Title: Figure 8.9.6 Augmented
Zone of Theoretical Visibility (ZTV)
of Full Scheme at Green Hill BESS

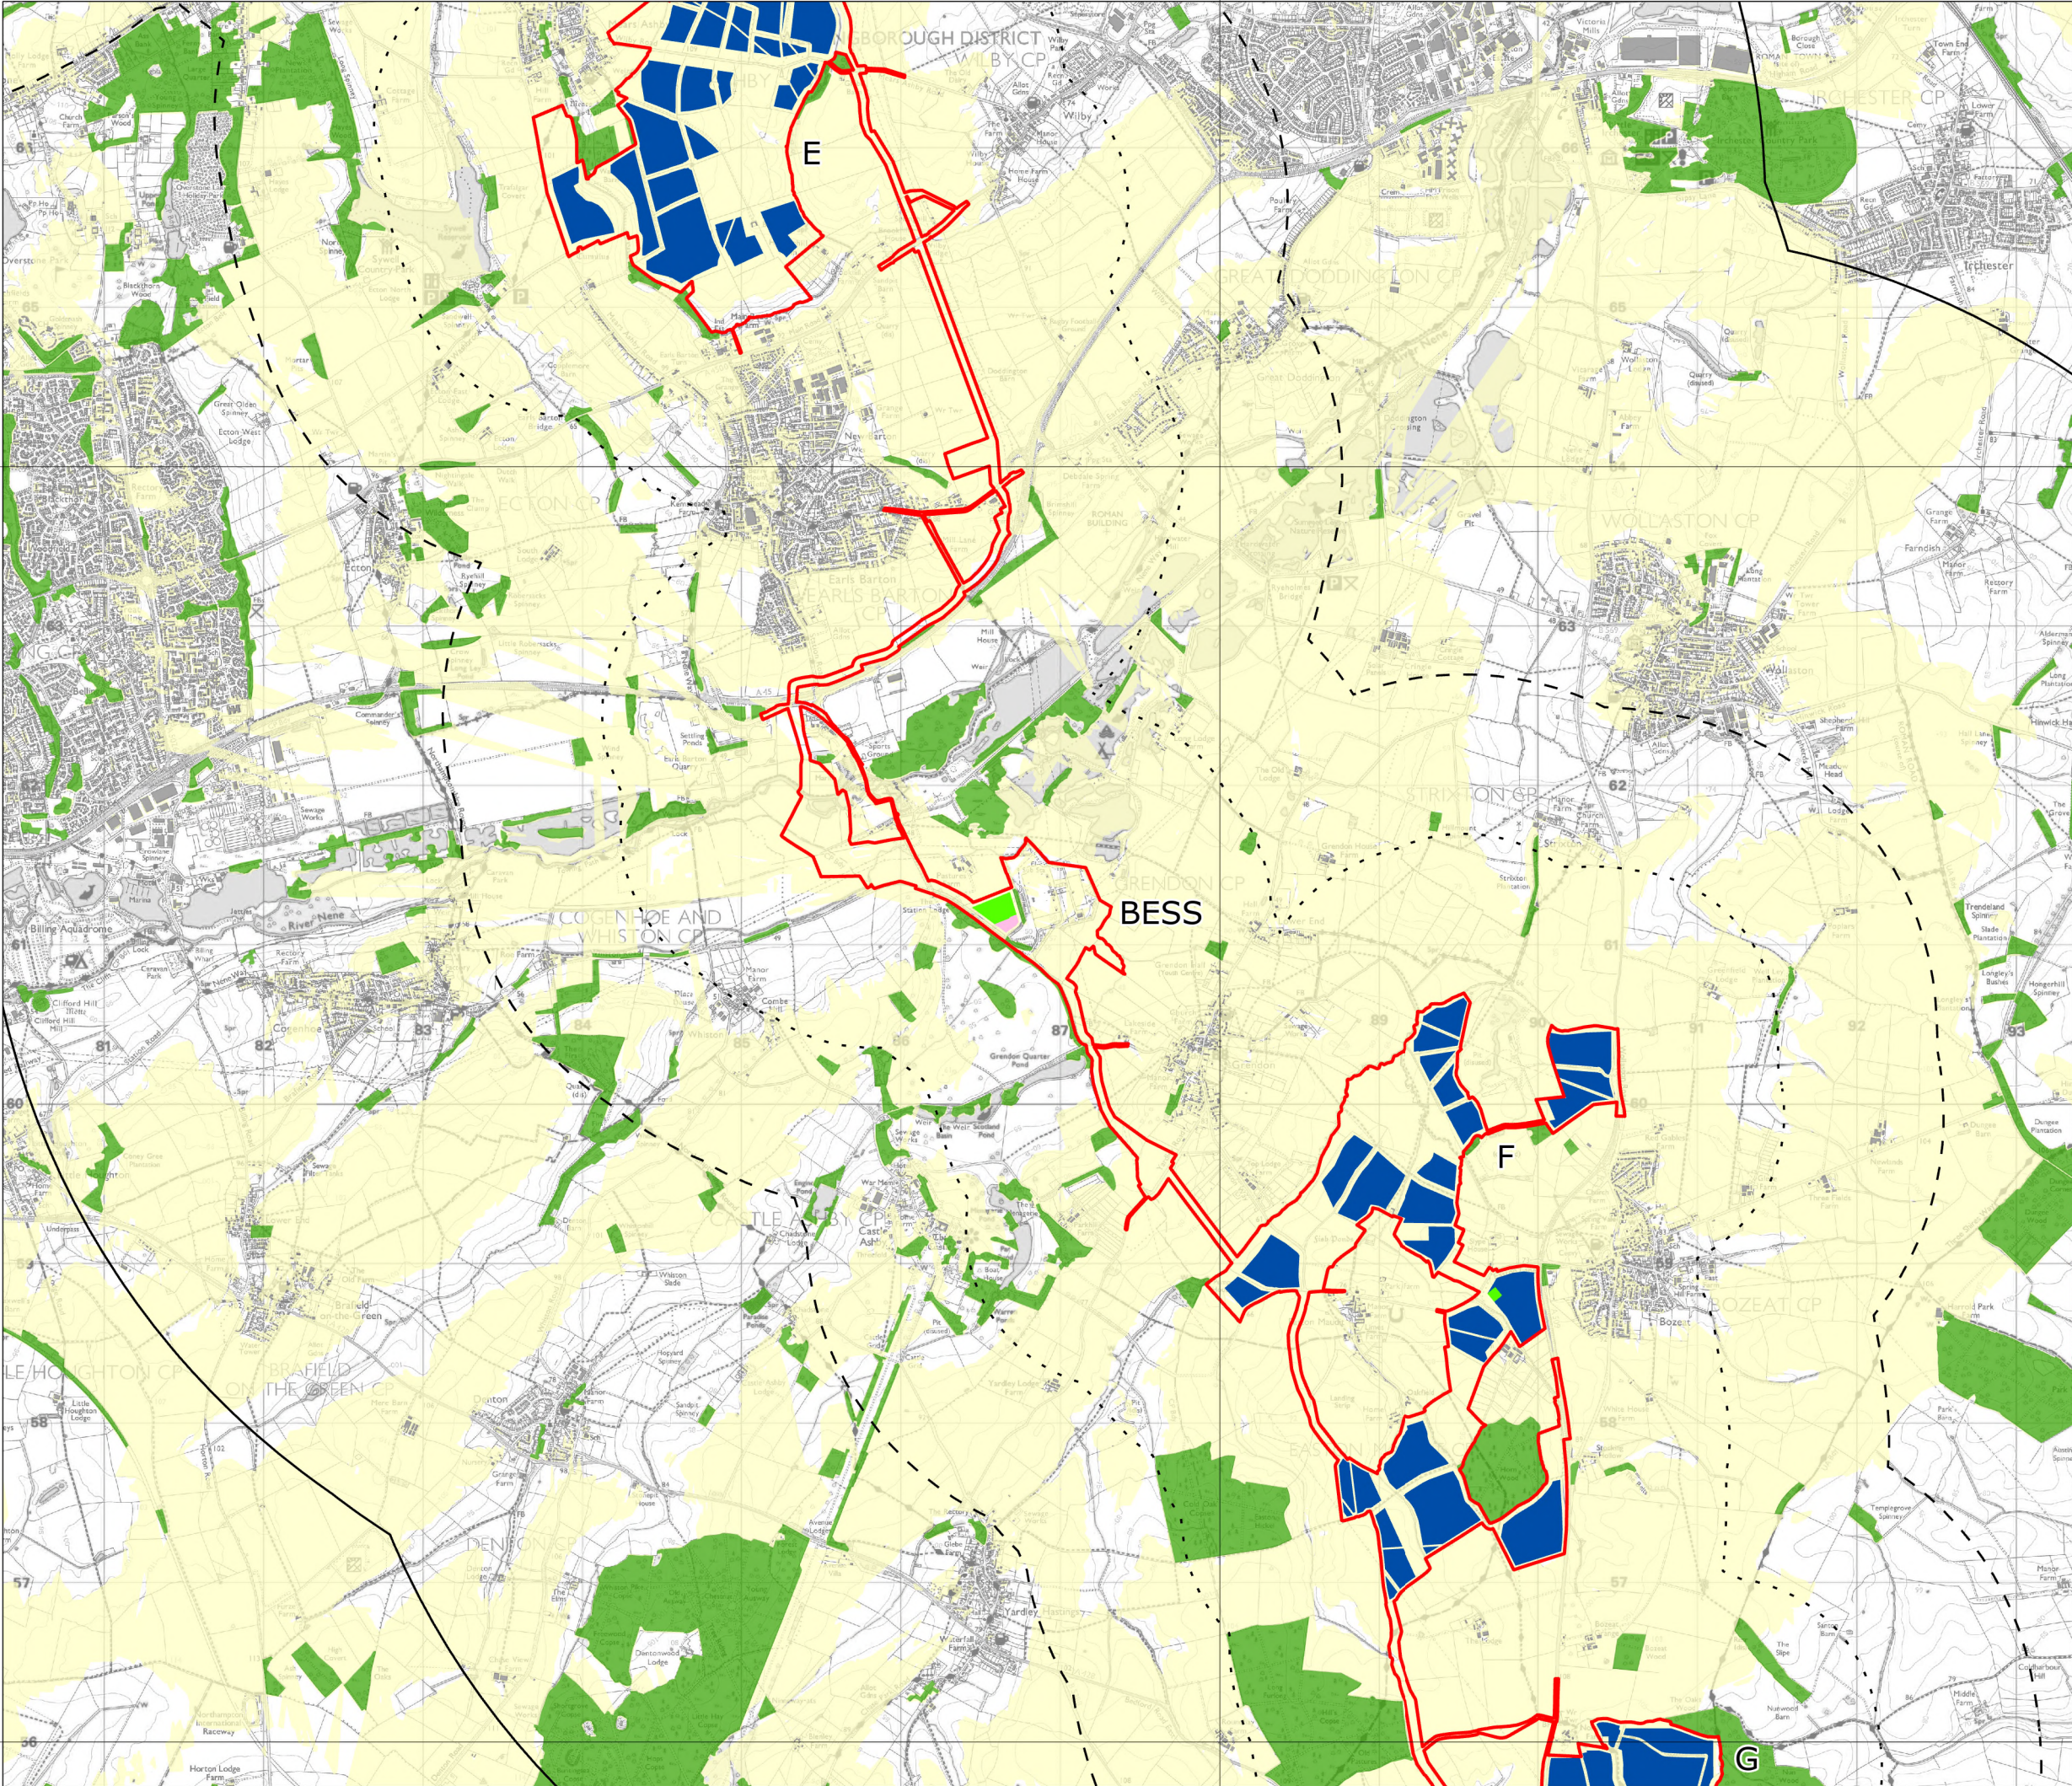
Unreasonably, upper floors have not been assessed and assumptions about non occupancy during daylight hours are methodologically unsound, fail to reflect real world use and render the Environmental Statement further incomplete.

Glint and glare is a health and safety issue as well as an amenity issue. The applicant has repeatedly ignored statements highlighting the omission of upper floor windows and has failed to rectify the omission. Proportional mitigation cannot be implemented without full assessment.

Therefore, it is reasonable and necessary to require removal from the scheme of all fields visible from dwellings with first floor or second floor windows overlooking the proposed site.
